28 January 2026

Canterbury Bankstown City Council Submission to the State Significant Development Application SSD-97092958 – 2 and 2A Bullecourt Avenue, Milperra

Council generally supports the application, however it is requested that revised plans and reports are resubmitted for further review.

TRUCK - ENTRY AND EXIT - ROAD 2 & HORSLEY ROAD

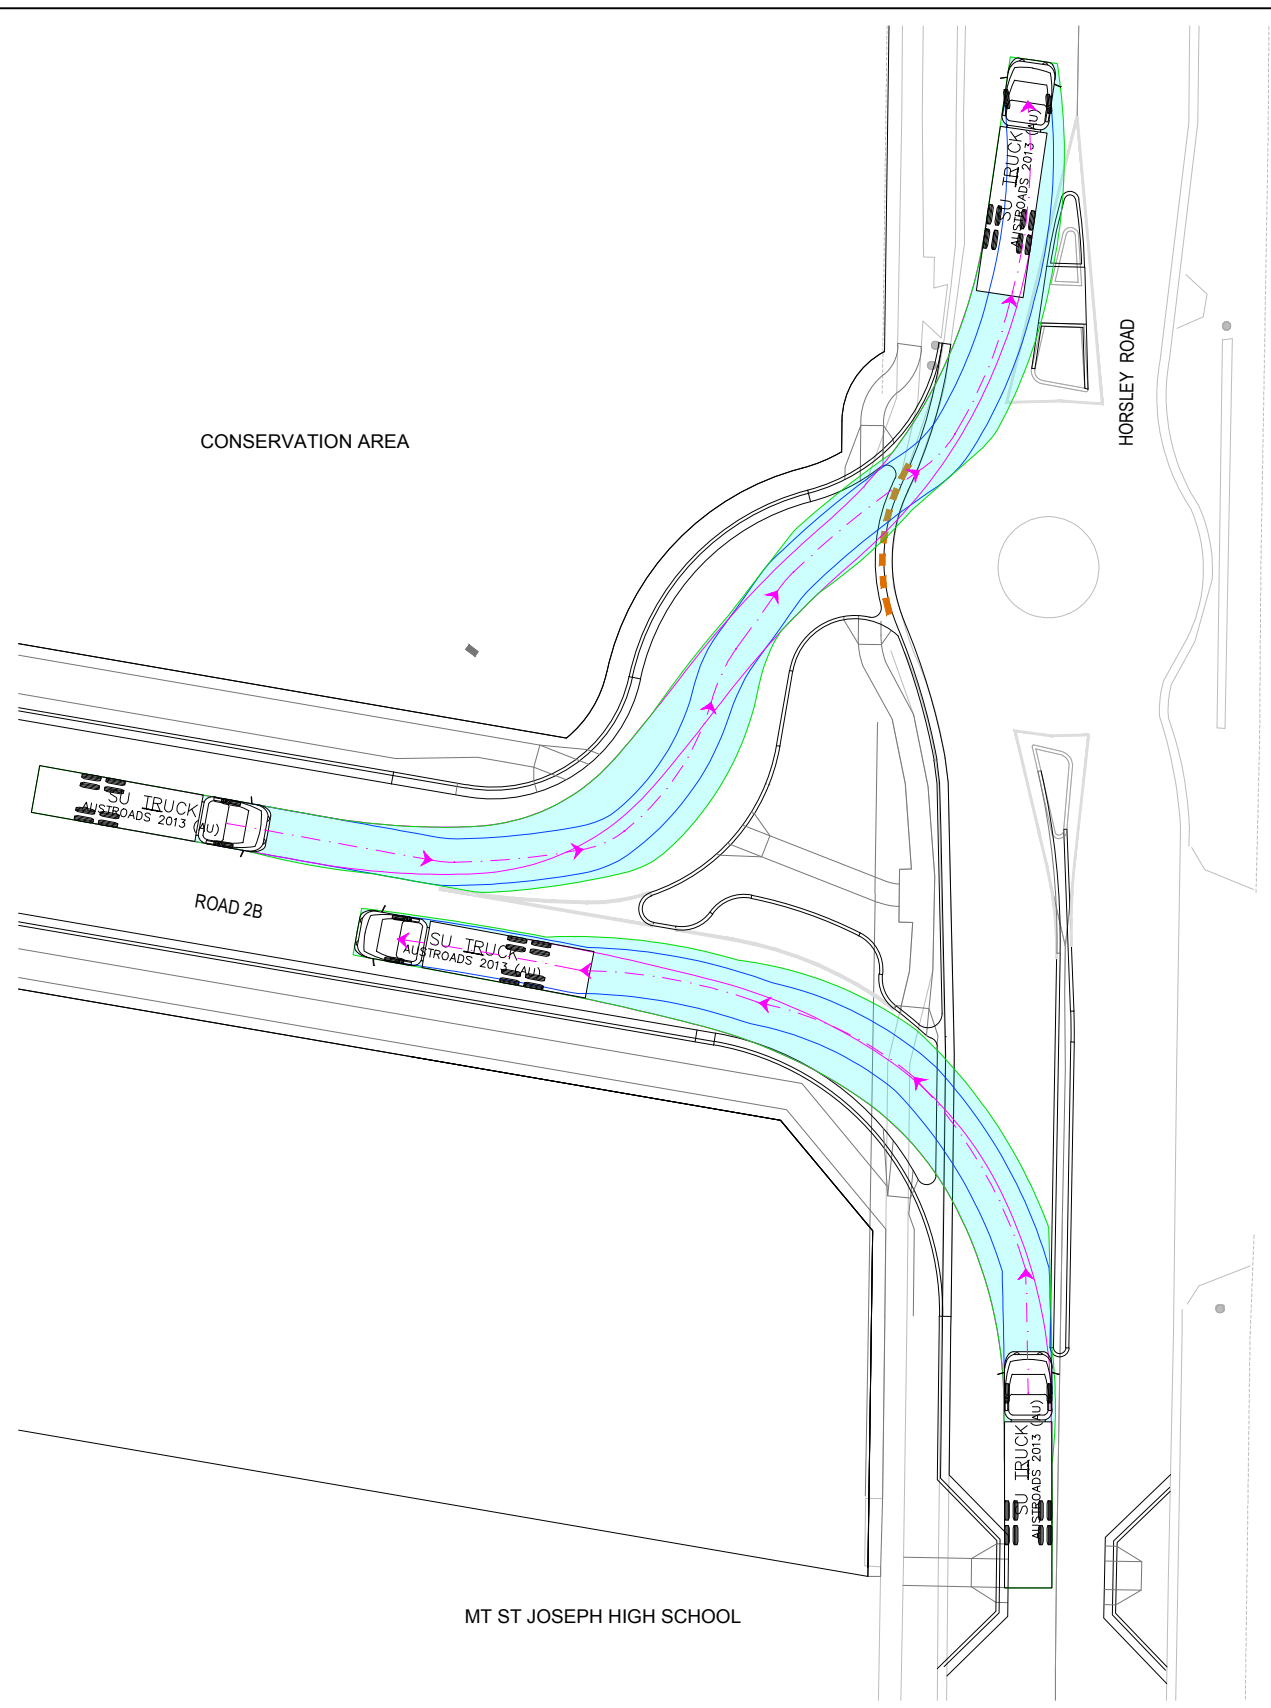
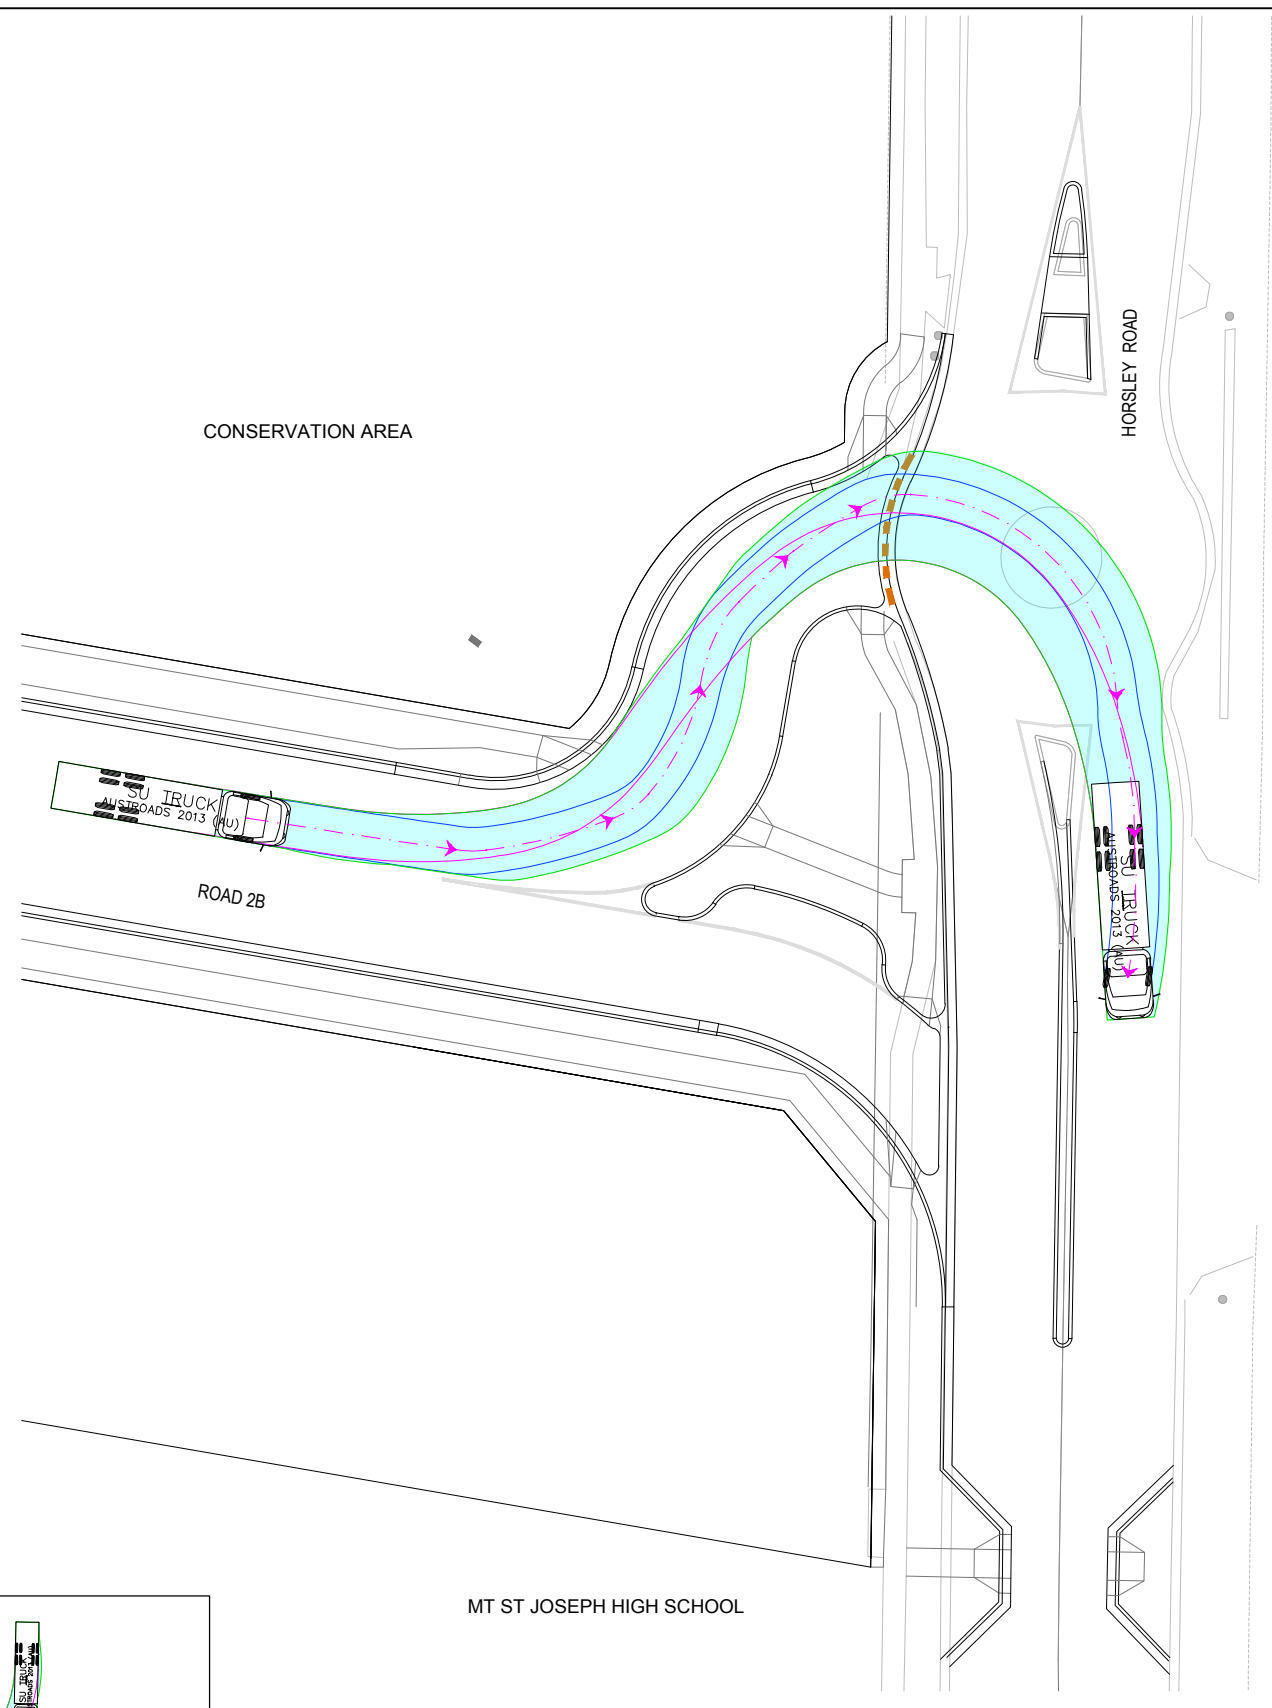
To reinforce the restriction on right-turn movements from Horsley Road into the access road, it is recommended that the gap between the existing roundabout splitter island and the proposed median island (located between the left-in access and the southern kerb extension) be filled. This treatment will physically deter and prevent illegal right-turn movements into the access road.

It is also recommended that the Applicant reconstruct the northern splitter island to bring the roundabout up to current standards with respect to pedestrian refuge width. The existing pedestrian gap measures approximately 1.68 metres, whereas current standards require a minimum width of 3.0 metres.

It is acknowledged that upgrading the southern splitter island to incorporate a pedestrian gap may inadvertently encourage motorists to utilise this gap to perform a prohibited right-turn movement from Horsley Road into the access road. Accordingly, it is acceptable for the Applicant to instead provide a raised pedestrian crossing, kerb extension, or slow point further south of the access driveway on Horsley Road, as shown in Figure 3.4, to improve pedestrian safety without compromising the proposed traffic restrictions.
